# SUNNICA ENERGY FARM

8.44 Applicant's Response to Local Impact Report – Response to  
Annex E and Annex F

<b>Version</b>	<b>Date</b>	<b>Status of Version</b>
Rev 00	28 November 2022	Deadline 3A Submission

SUNNICA EAST SITE B,
SITE ACCESS I (SE-I)
NEWMARKET ROAD

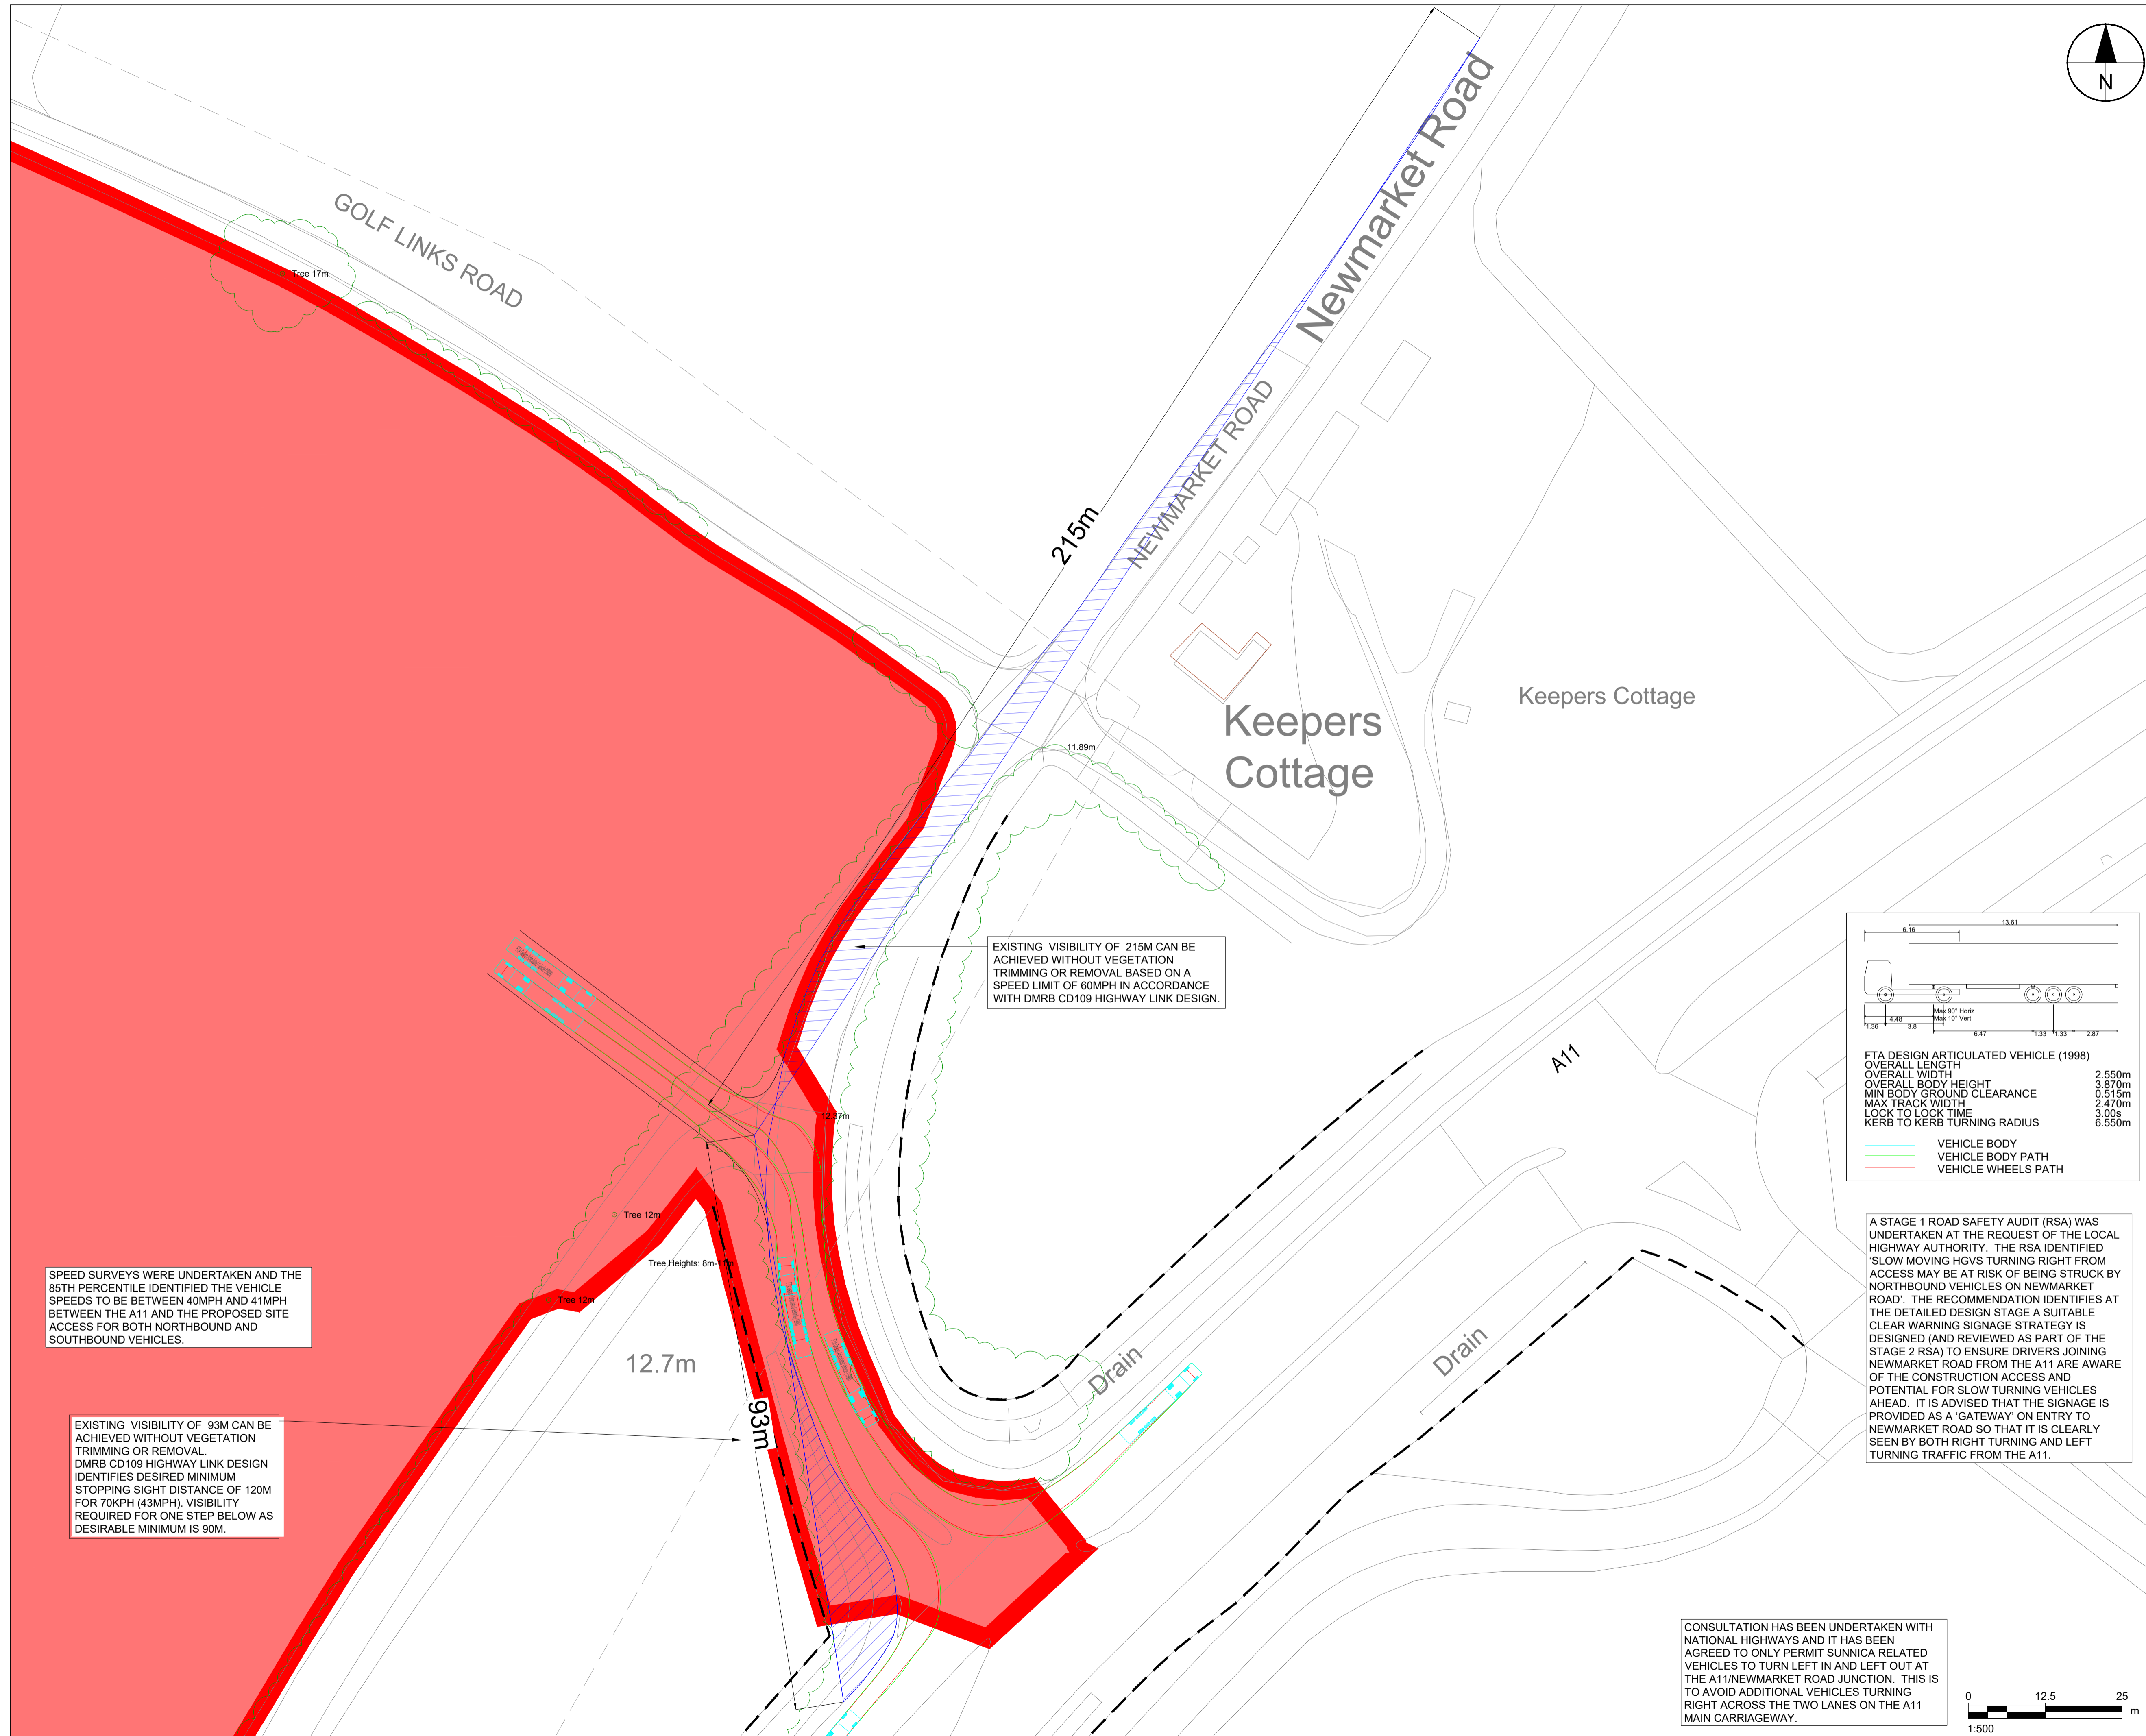
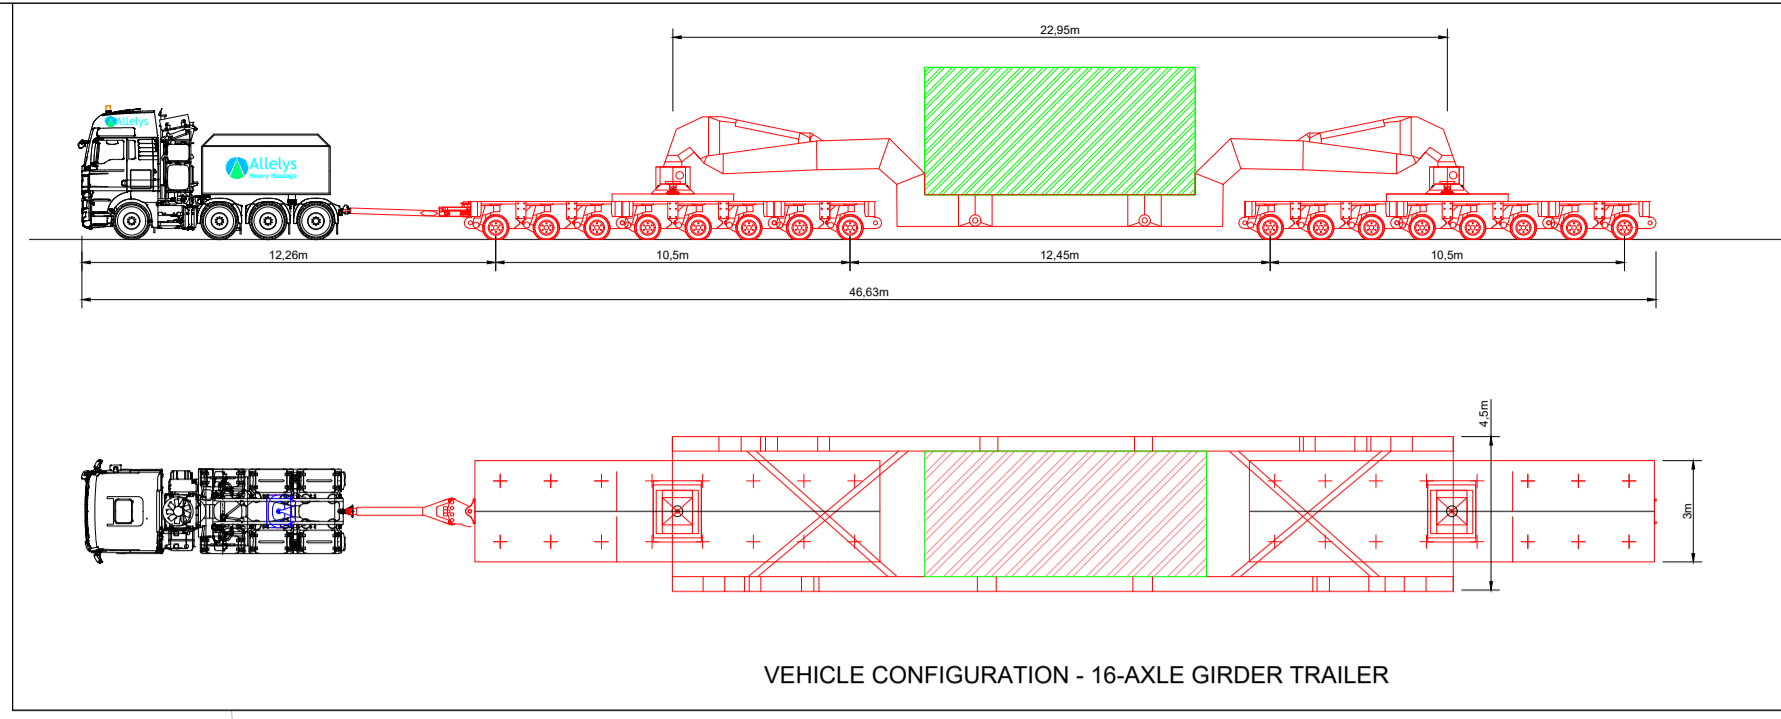
LIR Summary Reference (Para)	Summary of LIR Comment	Applicant's Response to LIR
	Sunnica East Site B: Site Access I on C576 Newmarket Road	<p>and Travel Plan submitted at Deadline 3A, and a summary of the position in relation to design at this stage and detailed design.</p> <p>The audit team initials are provided, along with their respective qualifications. The full names of the auditors will be provided to the Local Highways Authorities privately. As is clear in the RSA, notably Chapter 5, the Audit Team (Chelmsford) is separate to the design team (St Albans), and the RSA has been carried out in line with GG119. The Road Safety Team has had no other involvement in the project or Applicant other than the Stage 1 Road Safety Audit and are completely separate. Therefore, the use of an AECOM road safety audit team is considered appropriate and have the appropriate qualifications and experience to undertake the Road Safety Audit.</p> <p>A speed survey was carried out at the request of the local highway authority which recorded the speed of vehicles at the proposed construction site access. The results of the 85<sup>th</sup> percentile are presented in the Framework Construction Traffic Management Plan and Travel Plan [REP3-013-]. This identified the 85<sup>th</sup> percentile vehicles speeds to be 40mph. Therefore, the desirable minimum stopping sight distance to be 120m and the one step below desirable minimum to be 90m in Design Manual for Road and Bridges (DMRB) CD109 Table 2.10. Thus the 100m available is one step below the desirable minimum.</p> <p>The Stage 1 Road Safety Audit identified a signage strategy to be provided warning motorists of the upcoming site access which the Applicant has commented to providing. Therefore, the achievable visibility splay is above the one step below desirable minimum visibility for 40mph. It is also noted that National Highways agreed to the use of the A11/Newmarket Road junction for development related vehicles (left in and left out only). Therefore, it is considered the achievable visibility without vegetation trimming, the design of the site access to accommodate two-way HGV movements and the provision of the signage strategy as identified in the Stage 1 Road Safety Audit to be appropriate for this site access during the construction phase.</p> <p>The existing site access on Golf Links Road (Sunnica East Site B Site Access J) is proposed to be used during the operational phase and not during the construction period. Currently, the Applicant does not envisage improvements being required to this existing access to the site, due to the very infrequent use it will receive during the operational phase.</p> <p>Swept path analysis of two-way HGVs has been provided at Sunnica East Site B Site Access I on Newmarket Road (located between the A11 and Golf Links Road). Further information is provided in the updated site access drawings which will be included within the</p>
